Inspector's Report ABP-308358-20

Whether a garage/store to the side of the dwelling house and a single storey extension to the rear of the dwelling house is or is not development or is or is not exempted development.

39 Kylemore, School House Road,
Castletroy, Co. Limerick

EXTENSION PLAN
SCALE 1:100

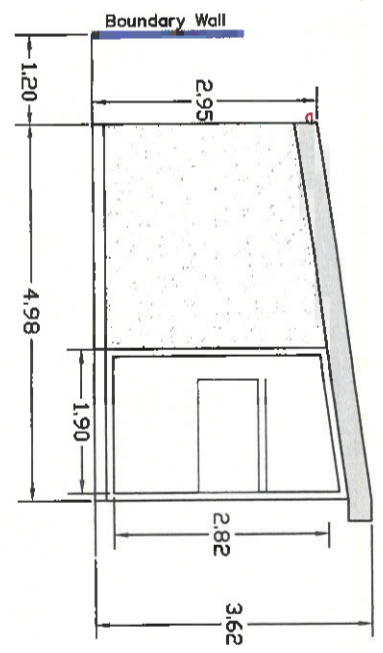
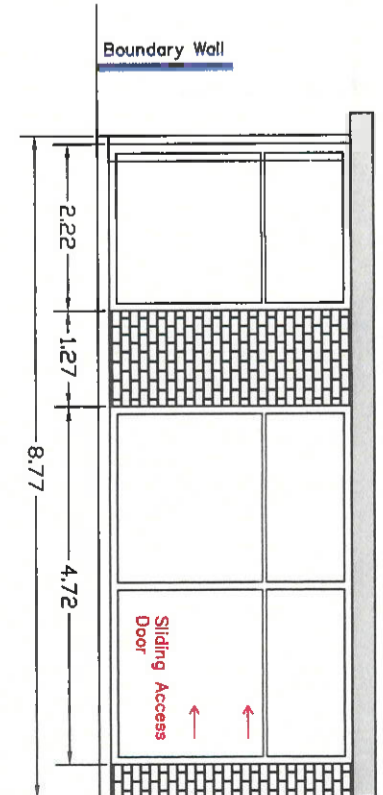
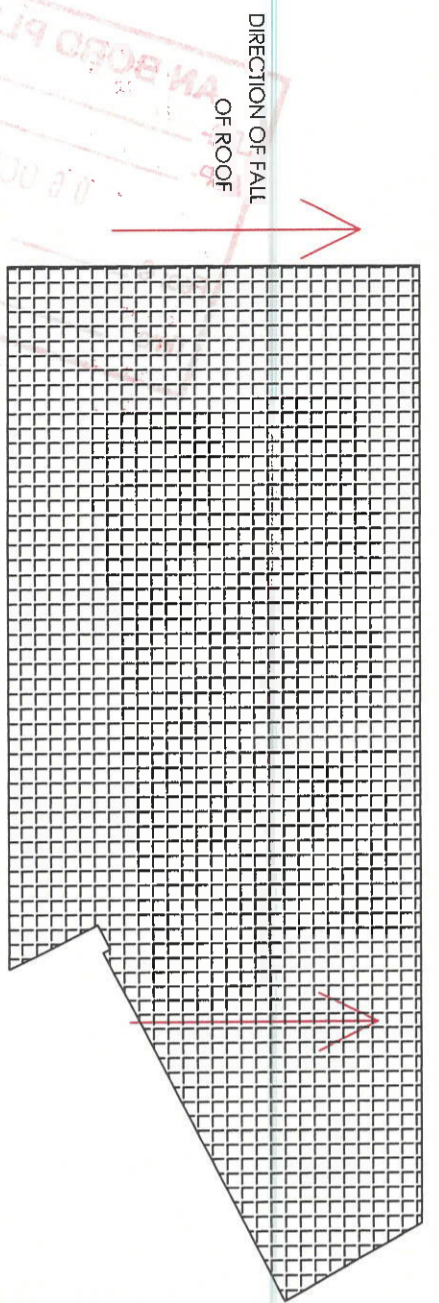
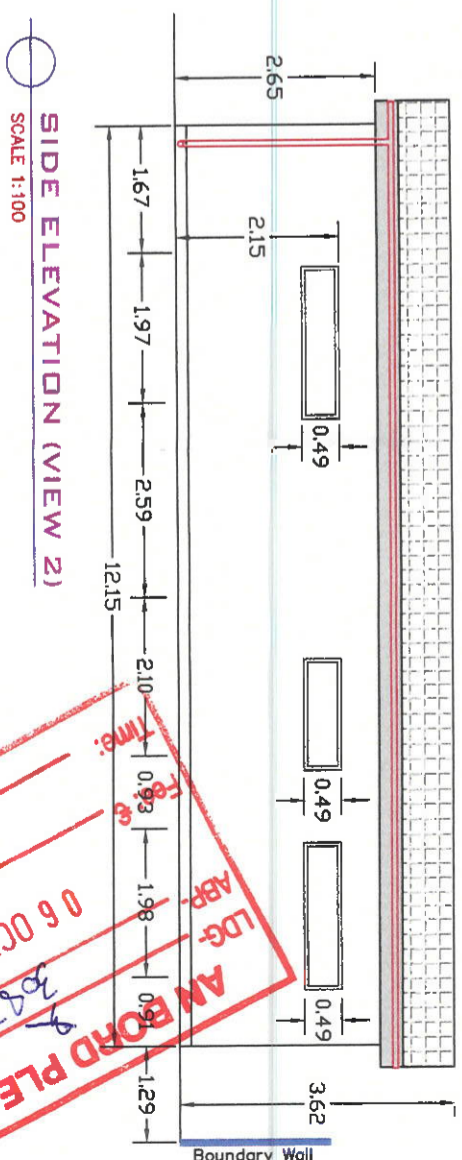
- Notwithstanding the privacy shields specified for windows in the south western and north western elevations of the building, these openings would continue to be windows and as such they would be variously 0.9m and within 1m of adjacent boundary walls and so this building would not be exempt under Condition 6(a) of the aforementioned Class.

- The height of the garage/storage portion of the building is 3.62m and so greater than the maximum of 3m cited in Condition 5 attached to Class 3 of Part 1 of Schedule 2 to Article 6 of the Planning and Development Regulations, 2001 – 2021. In this respect, the roof pitch is 9 degrees and so within the commonly accepted threshold of 10 degrees for the categorisation of a roof as flat. Furthermore, its roof would be clad in metal decking and so it would not be “tiled or slated”. Accordingly, Condition 4 attached to Class 3 would not be met.

- The following irregularities in the submitted drawings are highlighted:
 - Under application 17/684, the floor area of the building was stated as being 41.5 sqm, while under the current Section 5 application it is stated as being 39.8 sqm. The observer scales it to be in excess of 40 sqm;

- Under application 17/684, the separation distance between the rear elevation of the building and the adjacent boundary wall was stated as being 0.9m, while under the current Section 5 application it is stated as being 1.03 sqm;
